87 Shillbank Lane,
Mirfield,
West Yorkshire,
WF14 0QW
10/06/21

Objection to planning application for residential development to the rear of no 28, Northorpe Lane, Mirfield WF14 0QN, application no 2021/62/91914/E

Proposed Site Layout

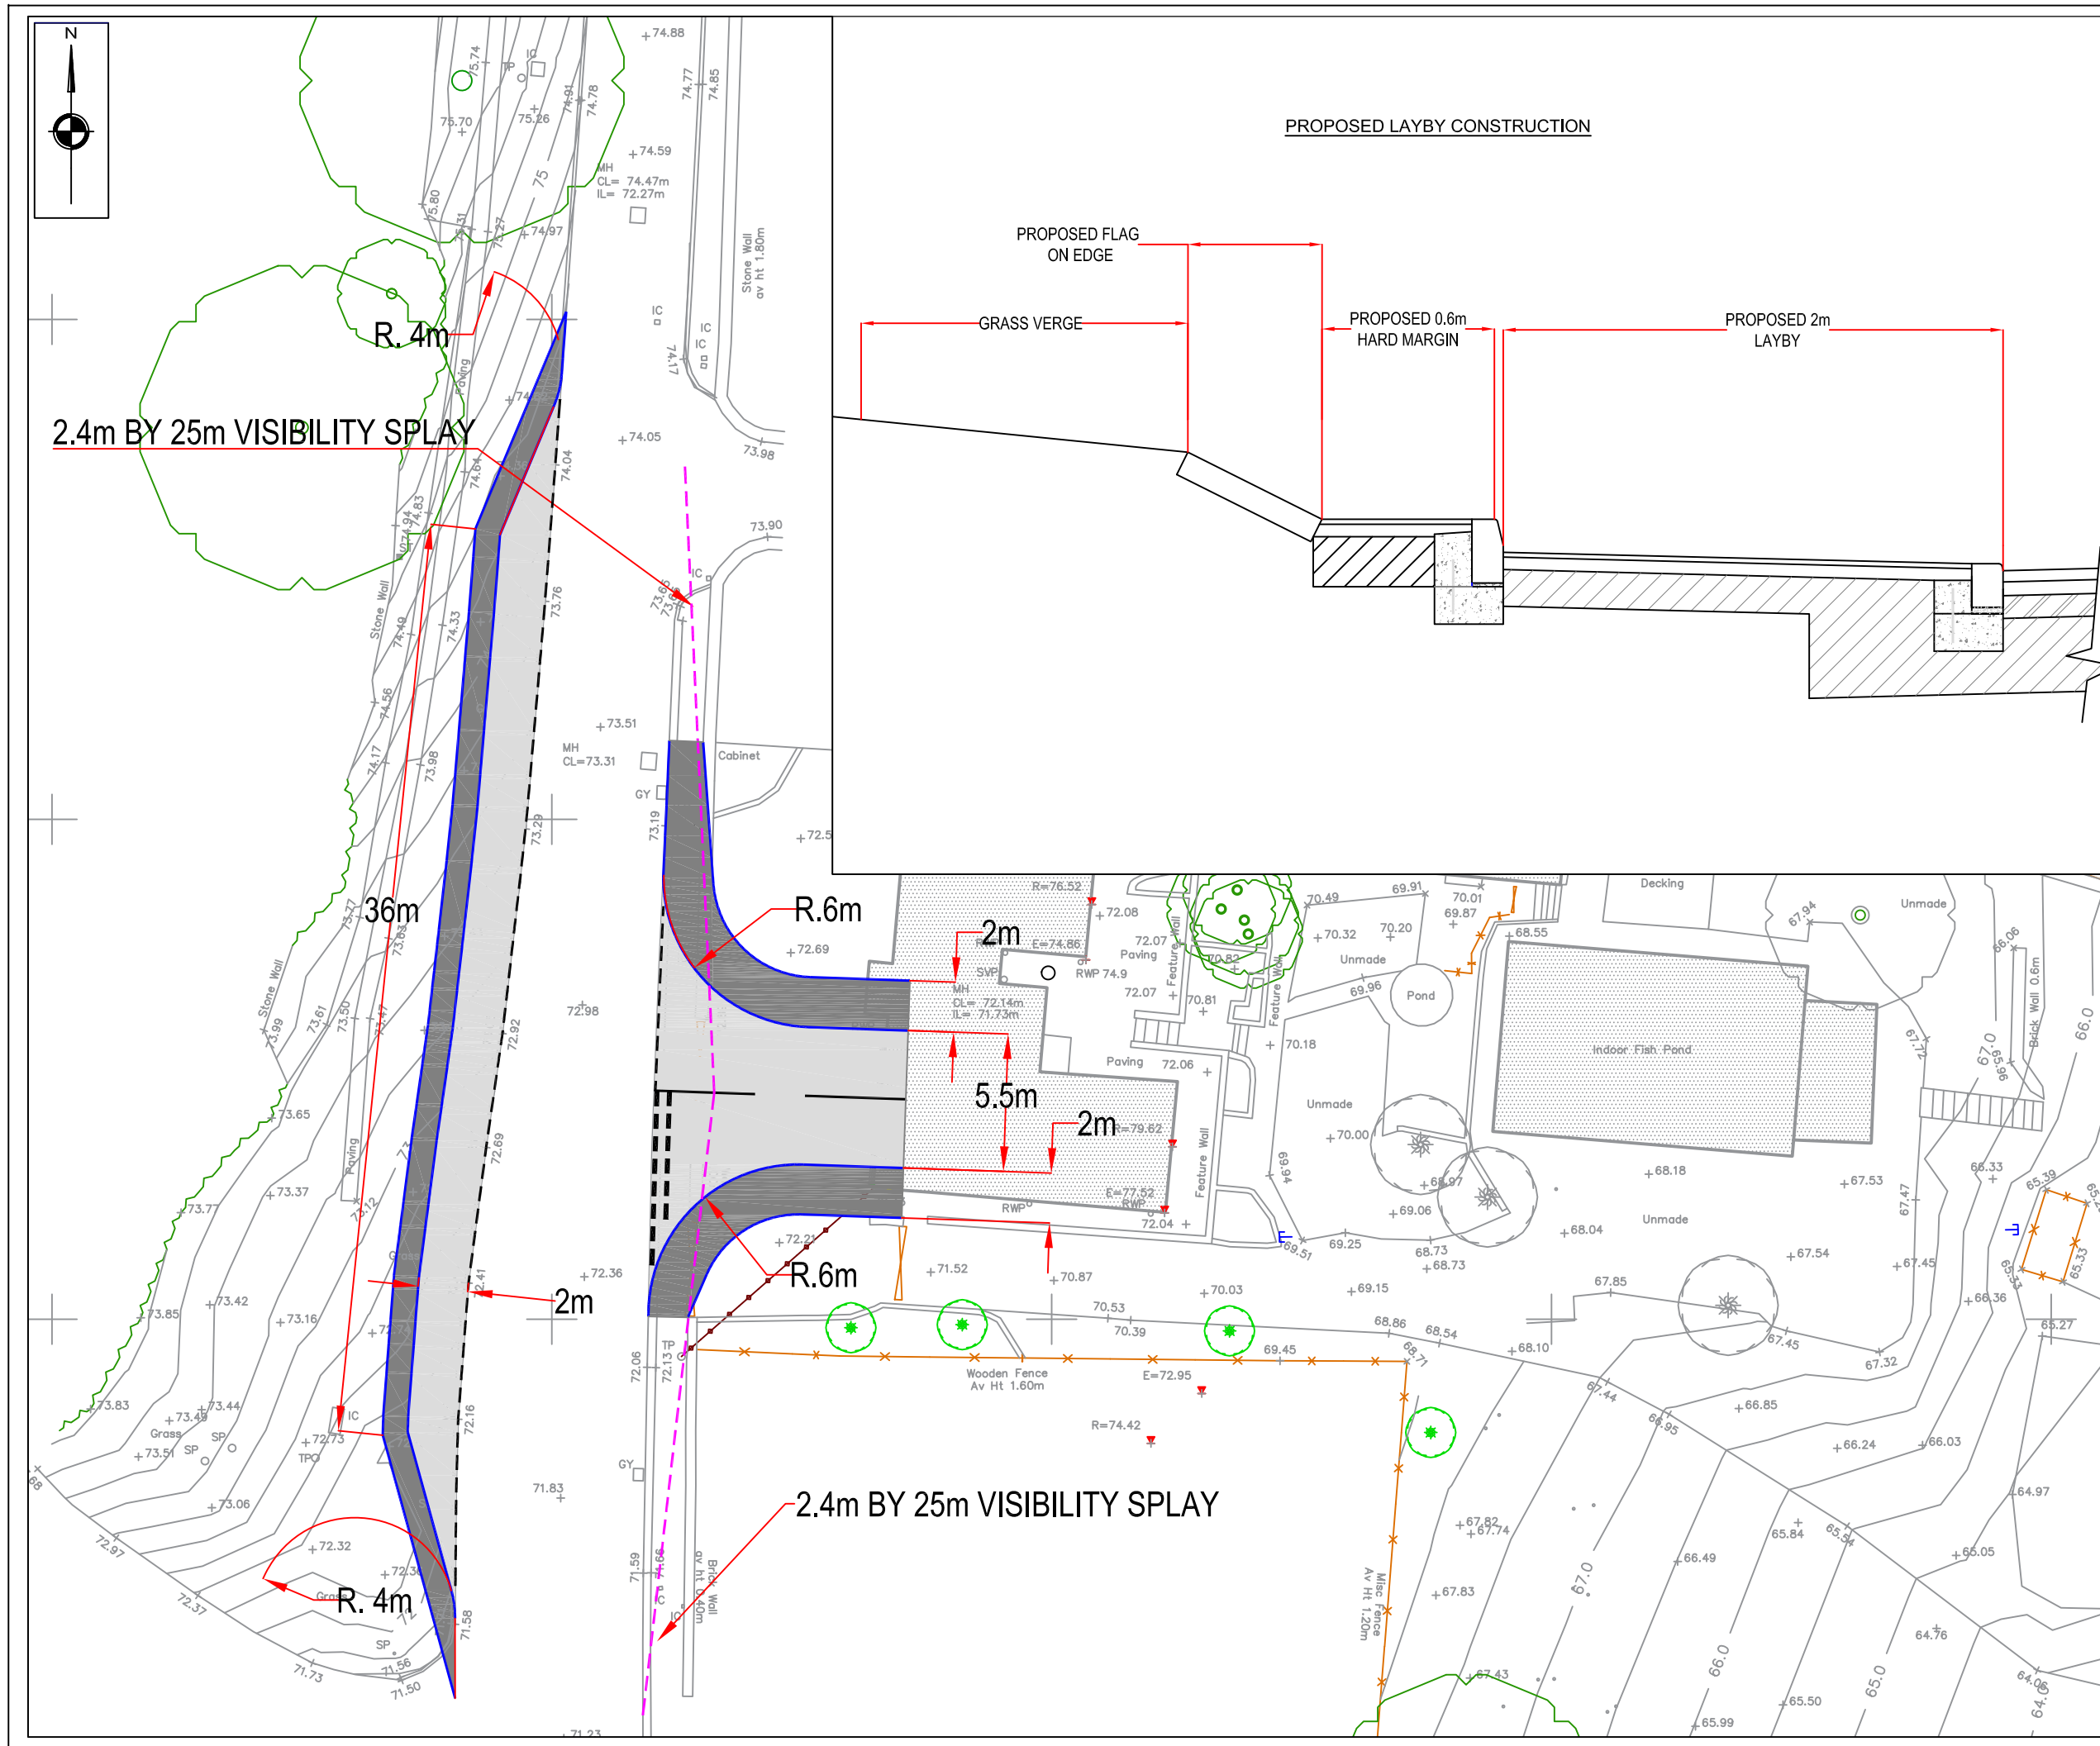
The land on which development is proposed acts as a soak-away for all the fields above it, it also slopes towards our property at 87 Shillbank Lane & dips along the Eastern side, this along with the problem of sewage removal, **the council's own planning policy has a presumption against pumping systems being used on residential sites, why is it being used here?** This is an admission that this site is unsuitable, what about the environmental consequences if this were to fail?

We have a number of mature trees on our North side which borders the site's South boundary which play a large part in absorbing ground-water & afford us privacy, what will happen to these trees considering they part overhang the plot?

As the Southern Boundary of the development would border our garden and the houses on Northorpe Court, how will the development be screened from view, given the close proximity to existing houses and gardens and the rural nature of the site. Will there be any provision for the planting of trees, shrubs, etc along the Southern Boundary in particular, and on the rest of the site in general, with the aim of absorbing water and screening existing properties from sight and noise. The plan does not appear to have adequate provision for this.
